From: Laura Gibbons
Sent: 05 July 2019 09:44
To: Richard Castro-Parker
Subject: RE: BE/139/18/PL - Innovation Centre Beeding Close

Please can the applicant submit clearer plans of the proposed surface water drainage arrangement. I.e. different line types used, rather than all very similar colours. Please can gullies, manholes, and linear drainage channels be clearly labelled.

- Proposed Drainage Layout – 1:100 Scale;
- Proposed Drainage Layout – 1:400 Scale.

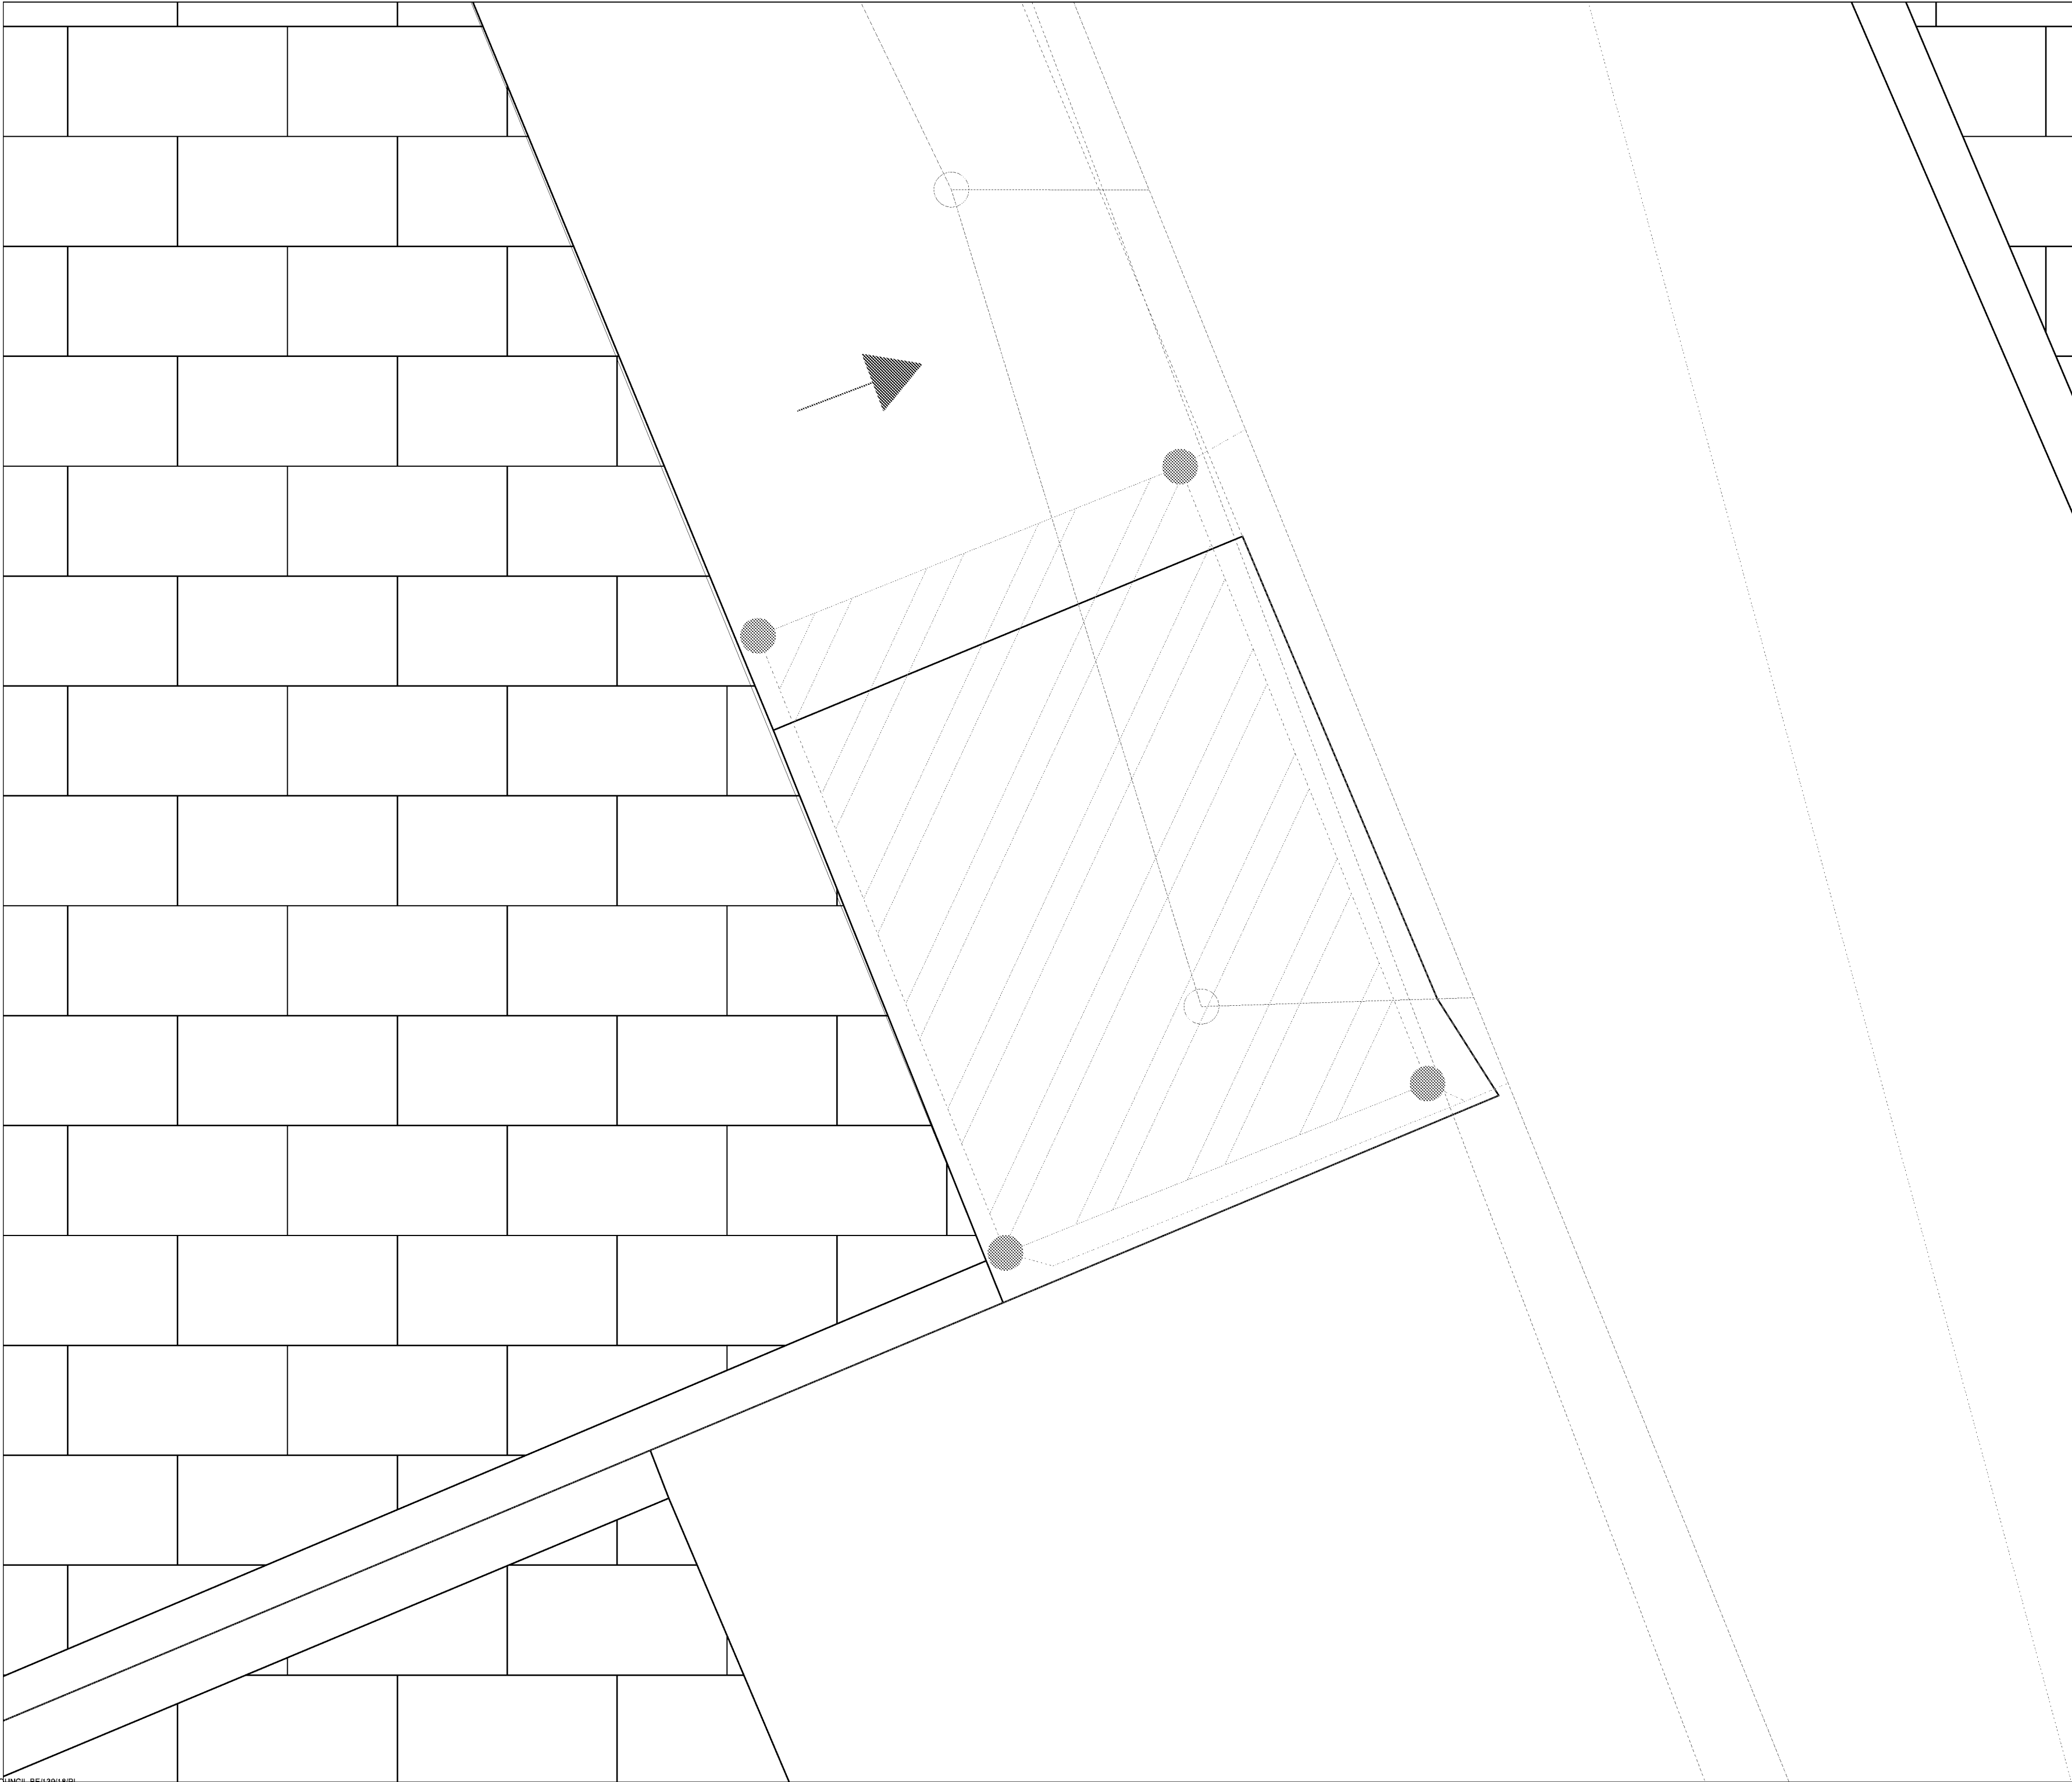
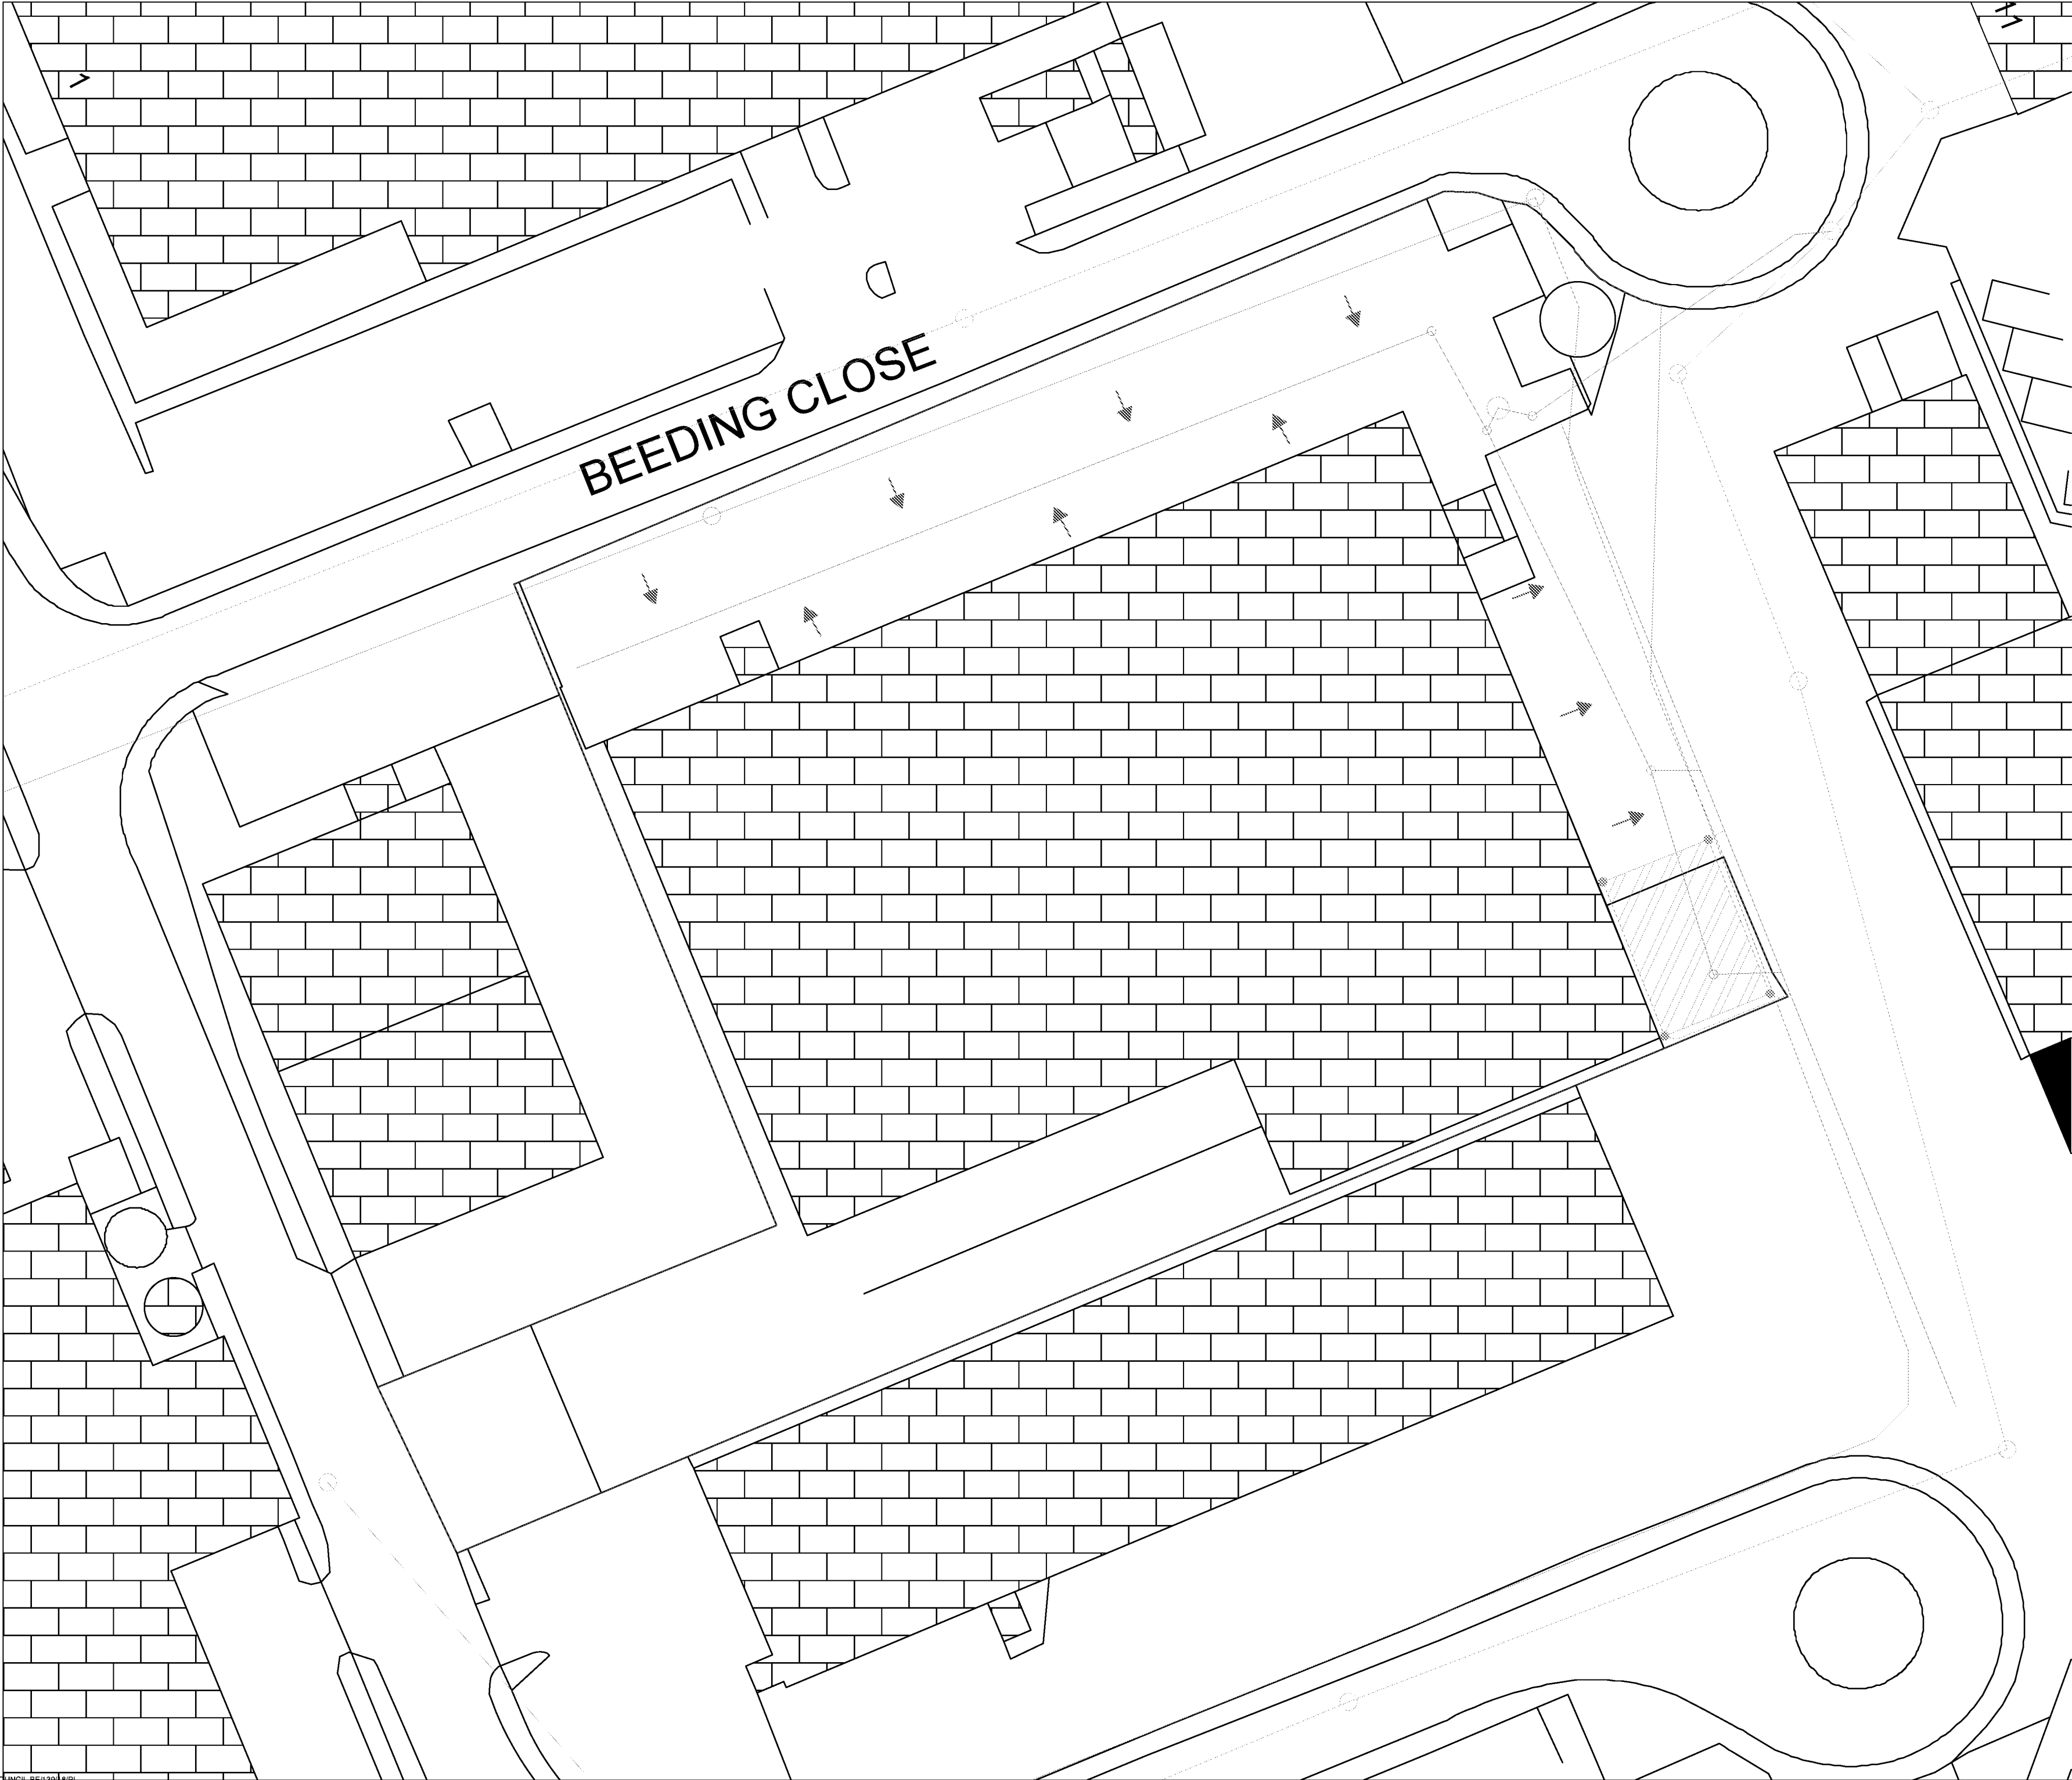
I also require levels to be submitted showing invert and cover levels of the existing drainage network and spot levels of the surrounding land. This is fundamental to ensure that the surface water from the development does not go off site.
